PROJECT NO. 1002071	APPLICATION NO. 02 DRB - 01290
PROJECT NAME Lands of McCarthy.	
EPC APPLICATION NO.	
APPLICANT / AGENT Mark McCarthy	PHONE NO. 301 - 1111
ZONE ATLAS PAGE H-12	
ONE STOP COMMENT FORM LOG

**20. Project #1002071
Application # 02DRB-01011
MRGCD Map 35**

Replat 2942 Carlota

PLAT OF TRACTS A & B - LANDS OF McCARTHY
 (BEING A REPLAT OF TRACTS 33-B-4-A & 44-A, M.R.G.C.D. MAP NO. 35)
 SECTION 12, T 10 N, R 2 E, N.M.P.M.
 CITY OF ALBUQUERQUE, BERNALILLO COUNTY, NEW MEXICO

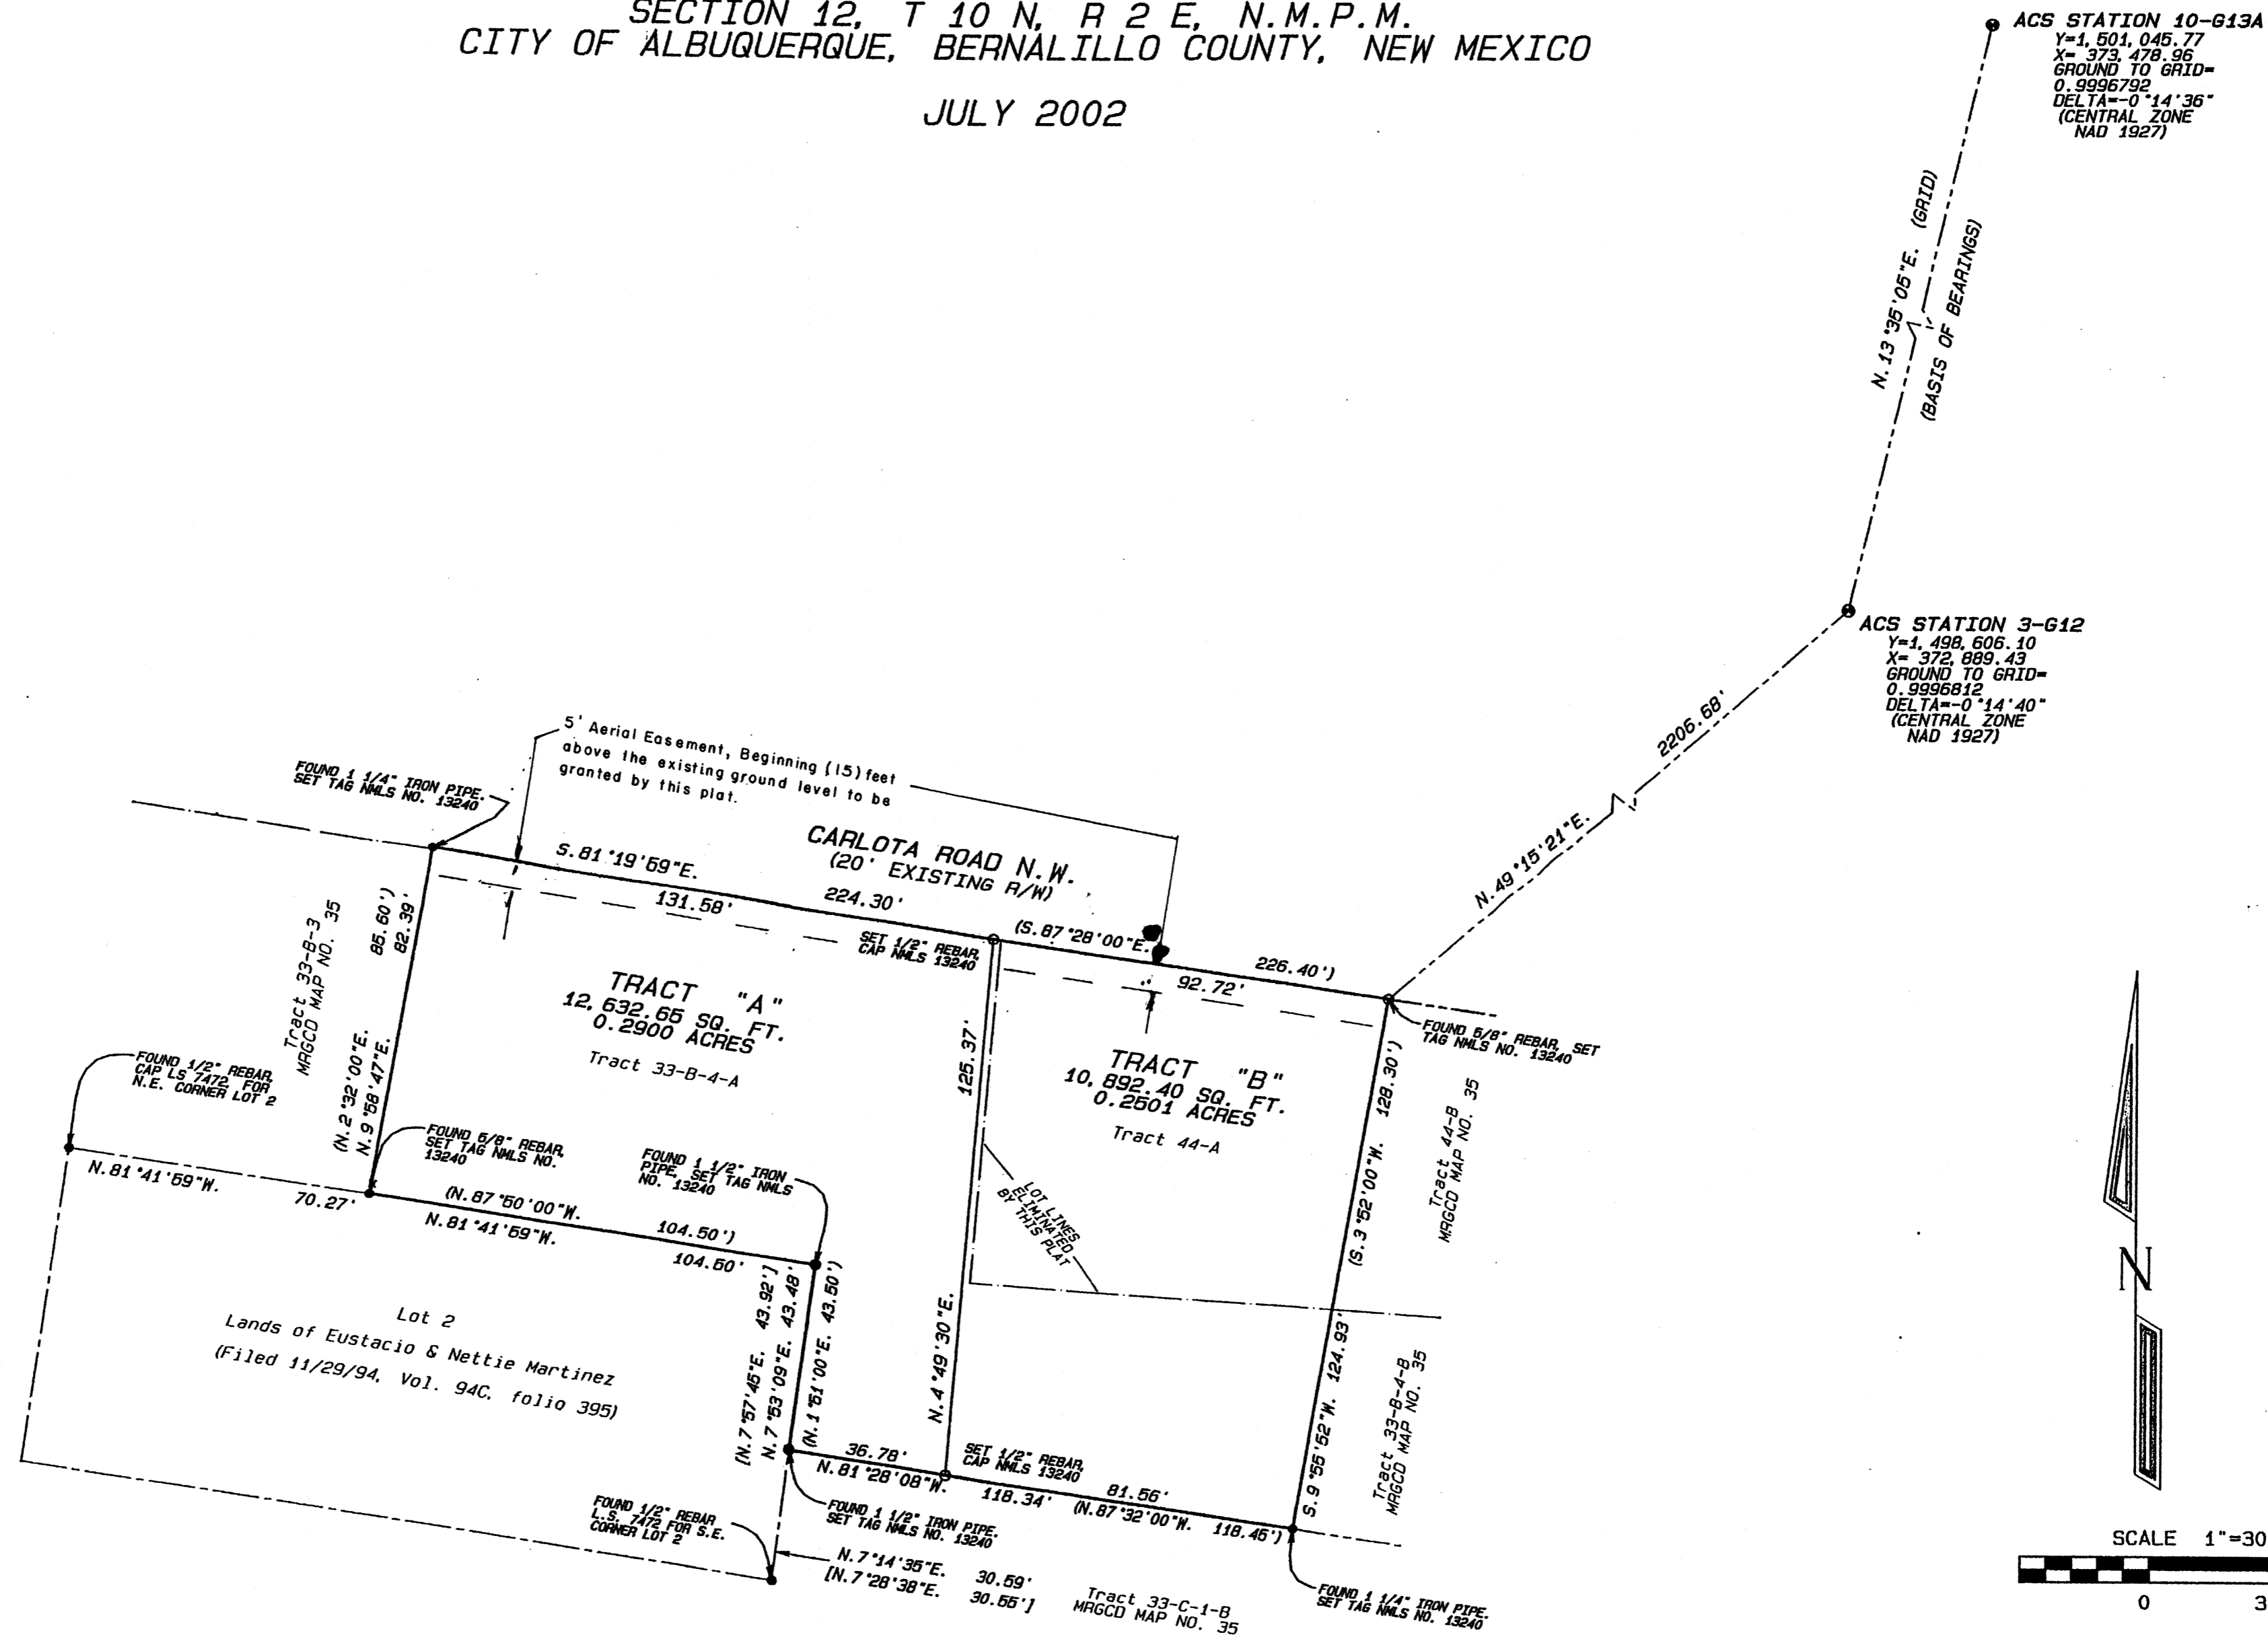
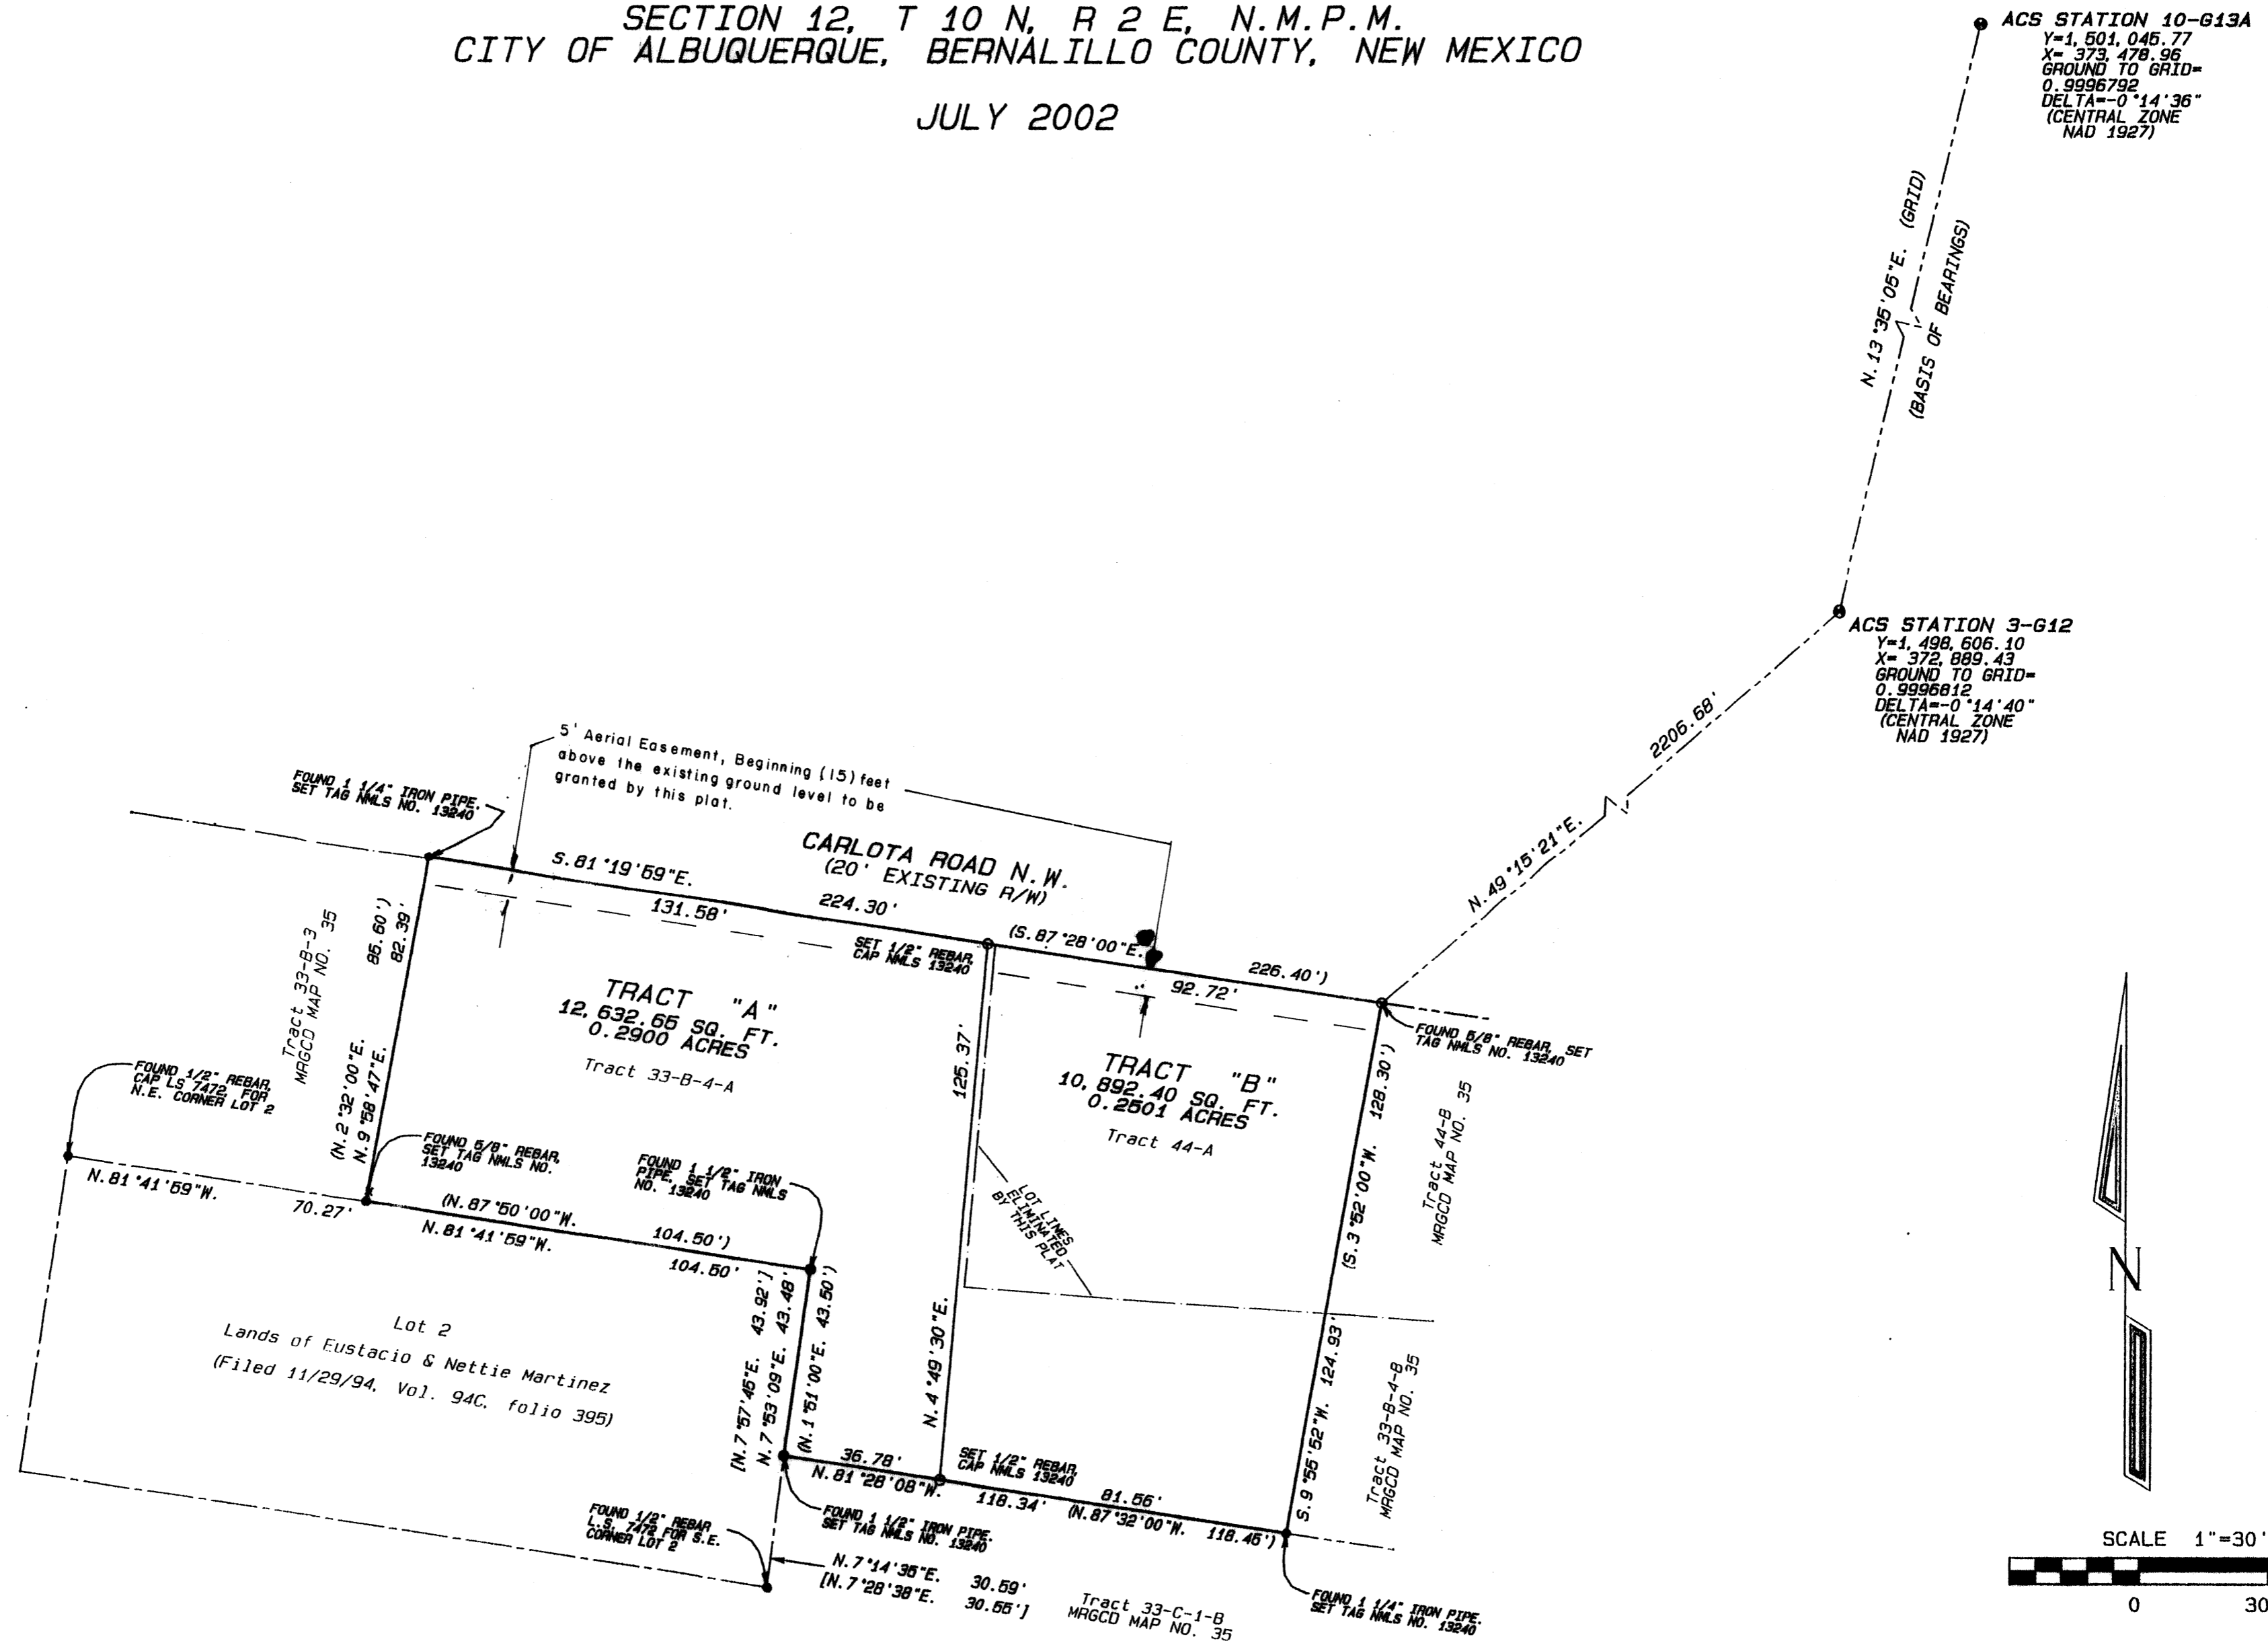
TRANSPORTATION DEV (505) 924-3990		
PLANS DISAPPROVED NSF	DATE 8/20/02	DATE
PLANS APPROVED NSF	DATE 8/21/02	DATE
COMMENTS:		
<ul style="list-style-type: none"> • Provide site sketch of property fronting Carlota Rd. to determine if there is 9' from face of curb to property line (if not → 9' R/W dedication will be needed and it can affect 5' Aerial Easement) • What is 5' Aerial Easement? Utility? (define)

1. The proposal does not meet lot size requirements (see Tract 44-A). In addition, the existing residence will need a setback variance. Please reconfigure to meet lot size requirements, i.e. 10,890 square feet. In addition, please contact Tom Rojas, 924-3938, to discuss the setback variance.

Existing setback for the building is non conforming and will not affect the proposed replat.
